The Town and Country Planning Act 1990 (as amended)

Application for a Minor Material Amendment following a grant of planning permission FG/33/10/ for minor alterations to elevations of building, including lobby, energy centre & plant. Minor alterations to car park layout, landscaping & surface materials (this application also falls within the parish of Angmering)

Country Fayre Littlehampton Road Ferring

Proposed Site Plan

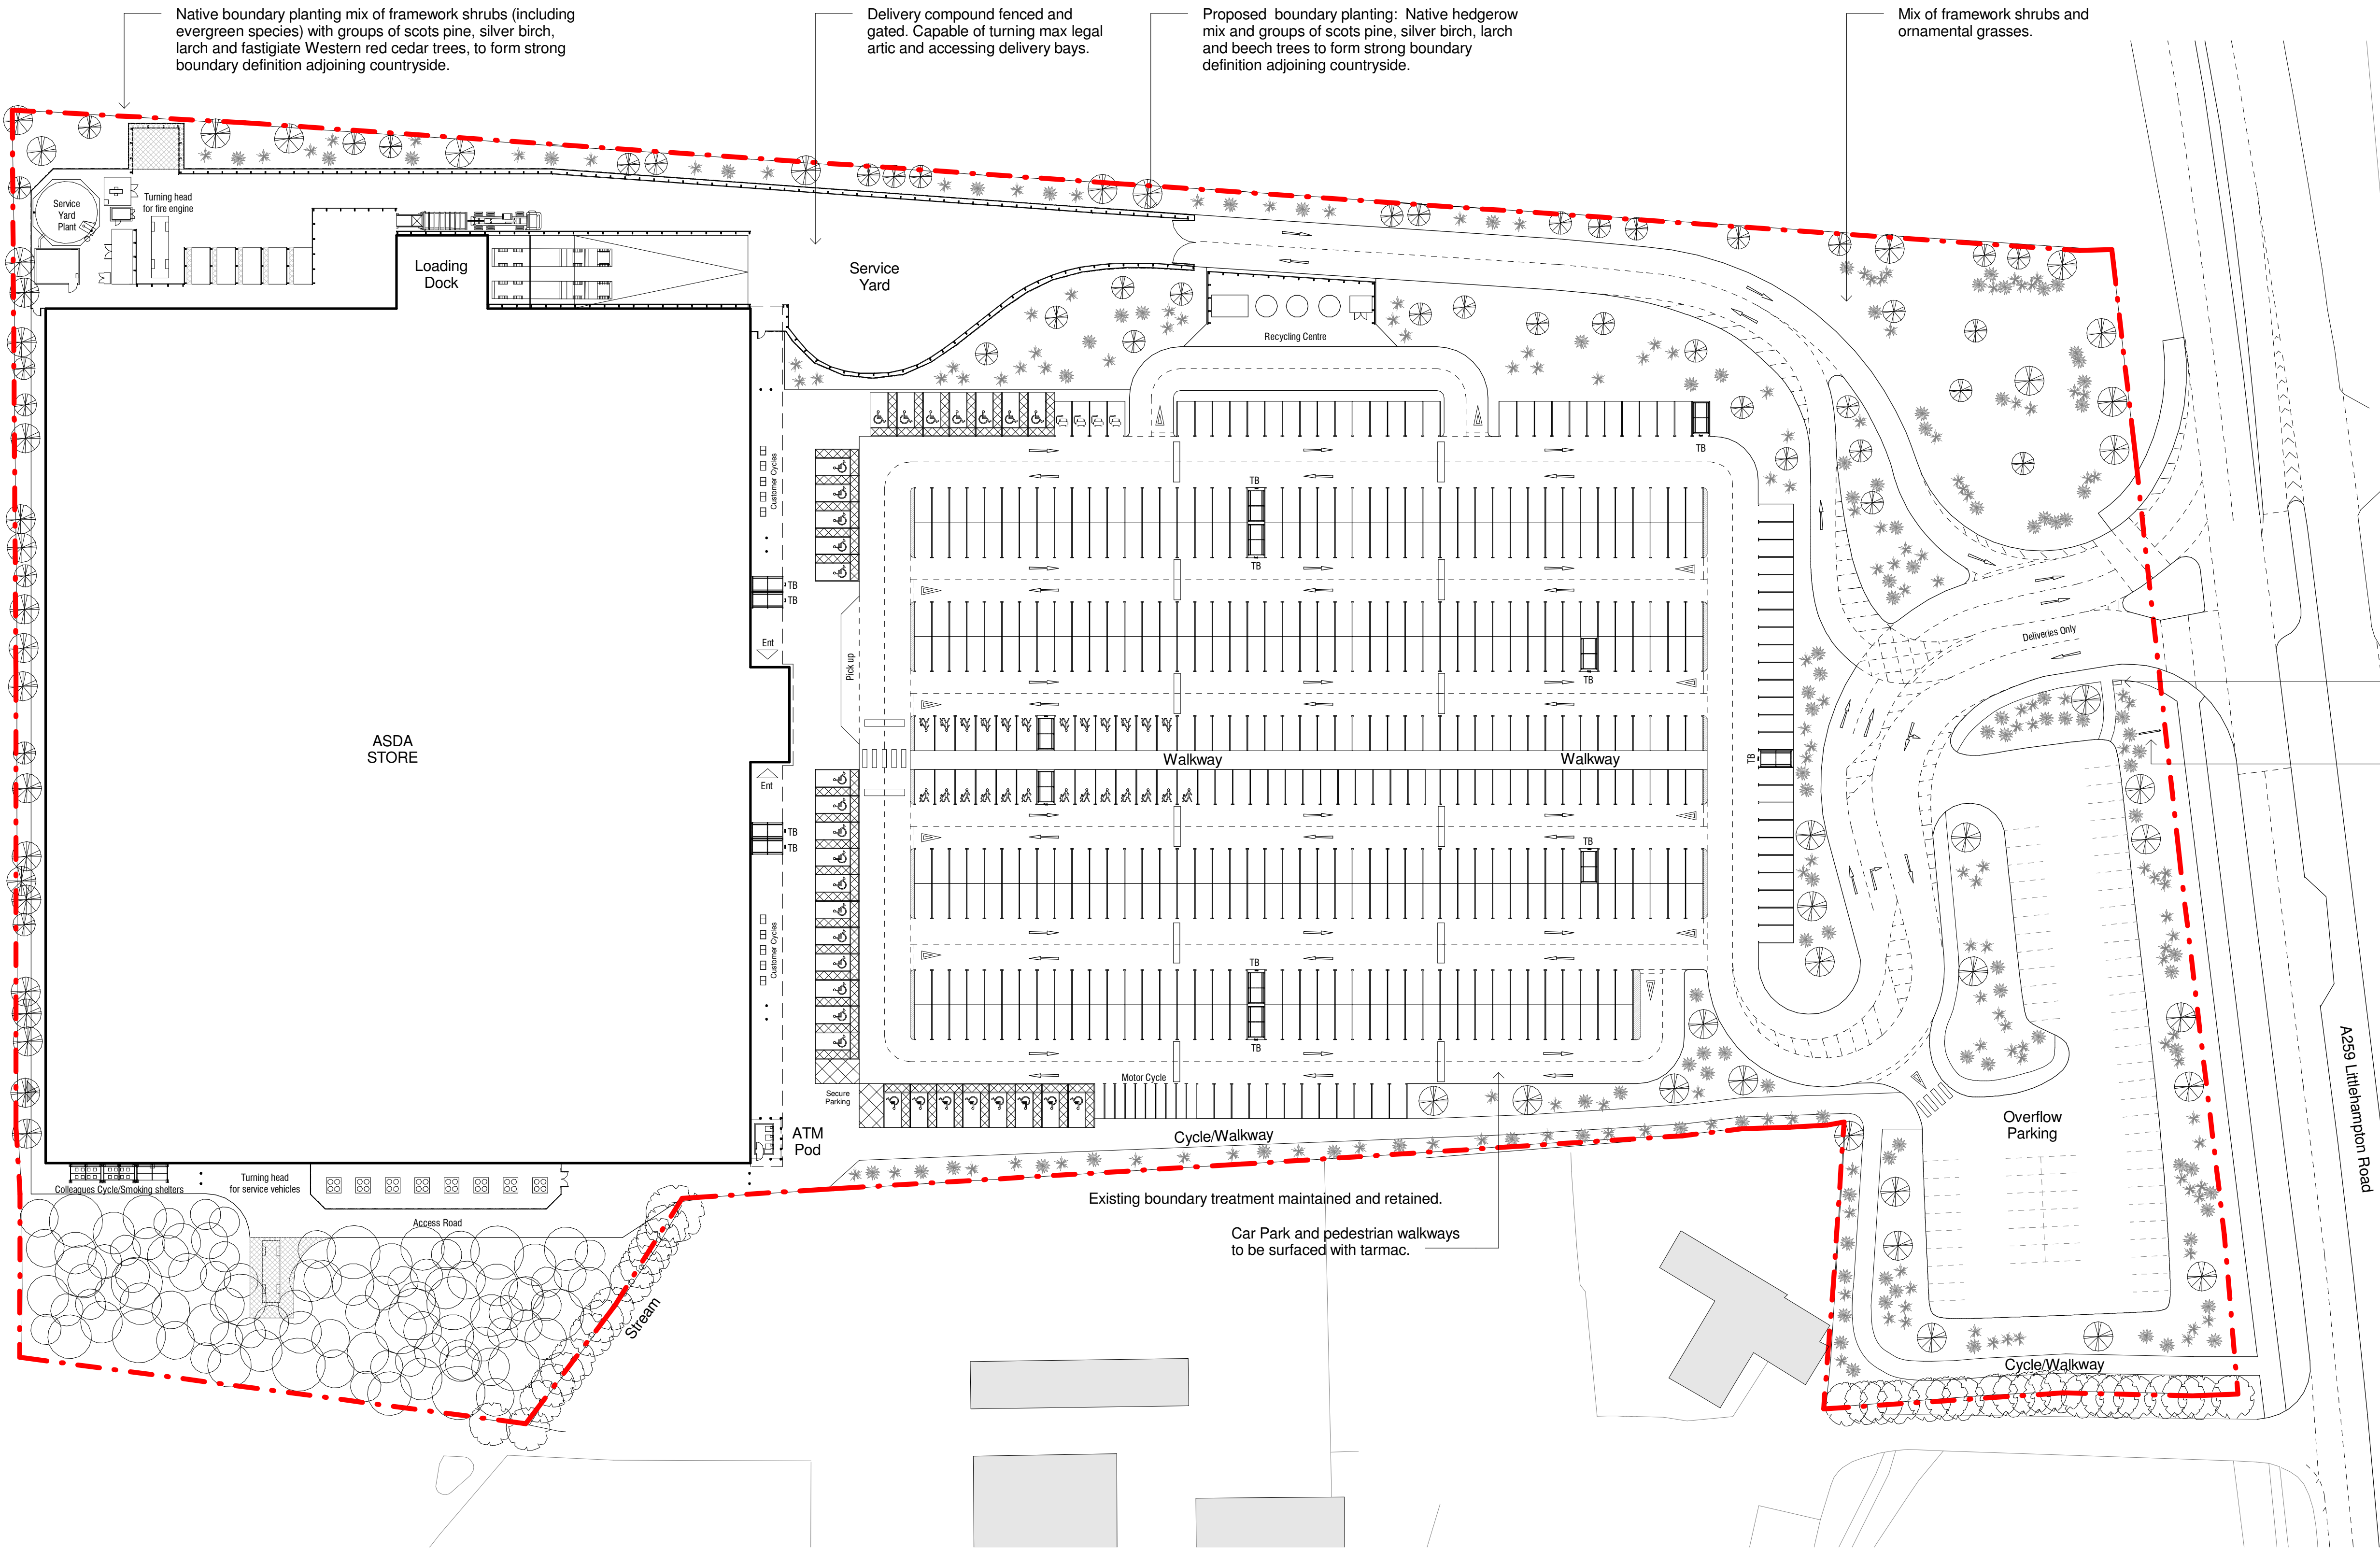
Highways Safety & Conflict of using revised exit/entrance points for both Service and customer traffic. No report on impact of vehicle movement within the car park area and how headlights could distract traffic travelling along the A.259.

Proposed Surface Finishes

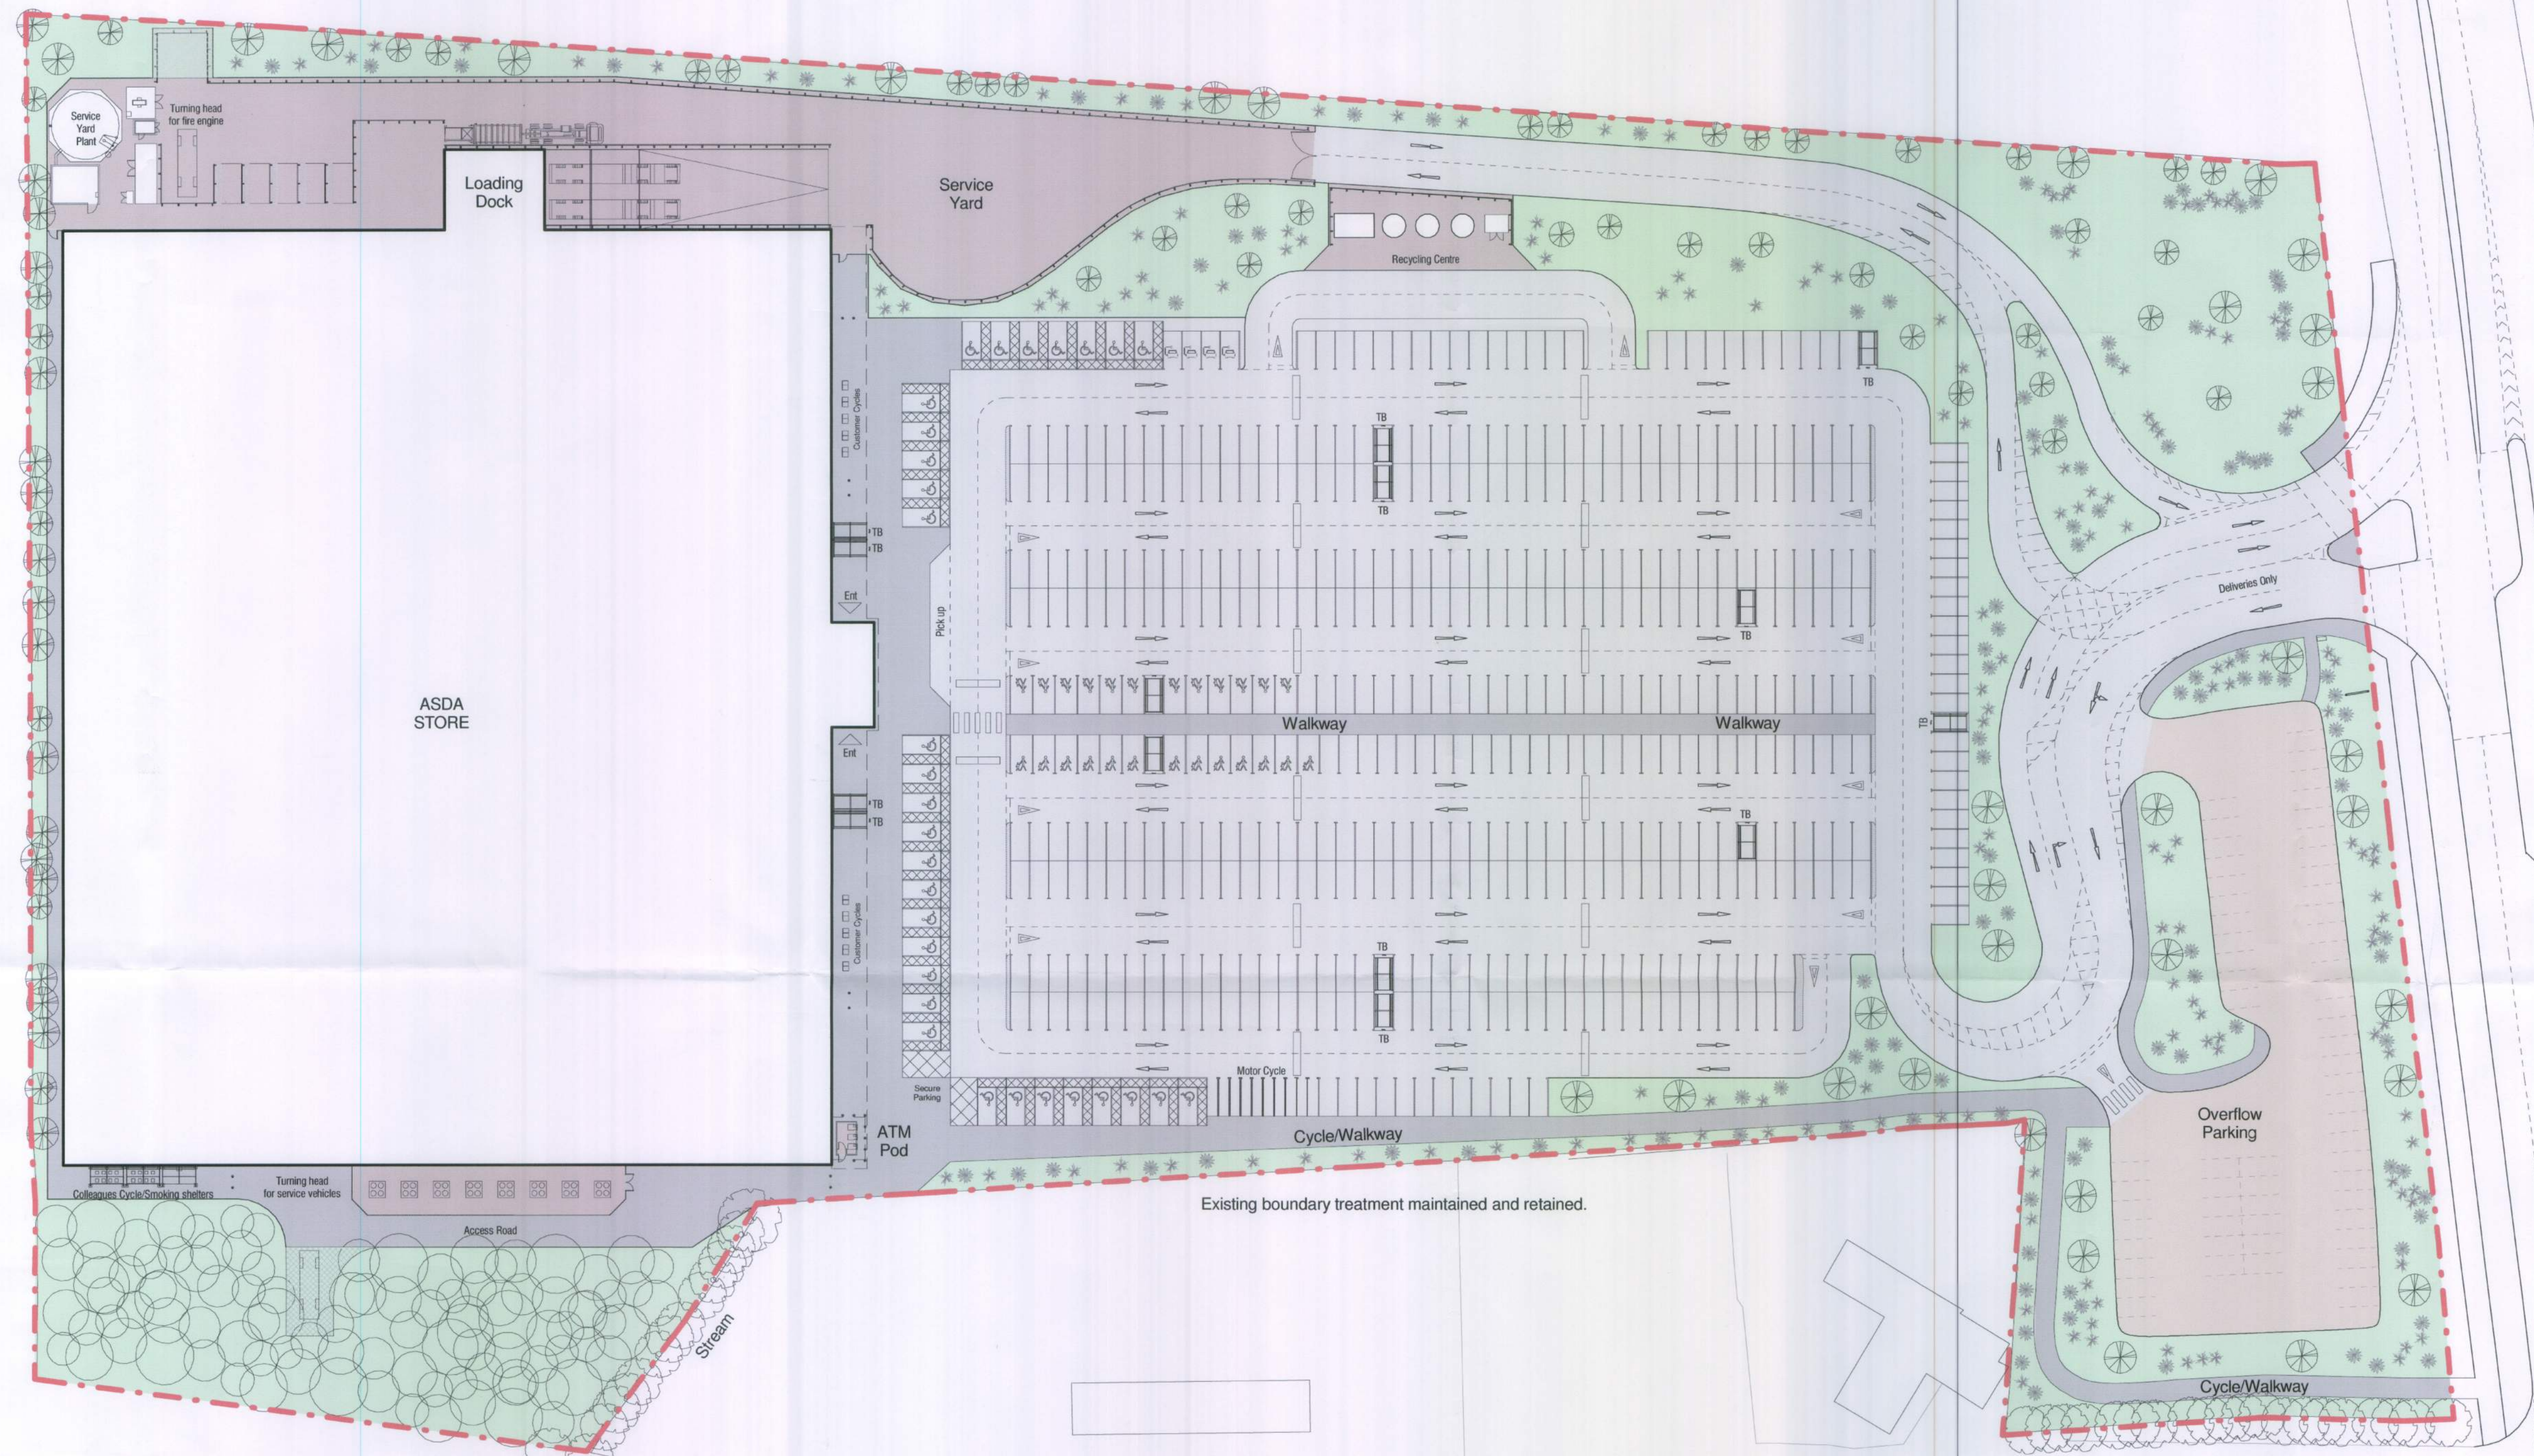
Parking provision & New layout and surface. No clear information on whether the proposed new surface will be permeable or is serviced by a sustainable drainage system in view of local flooding concerns.
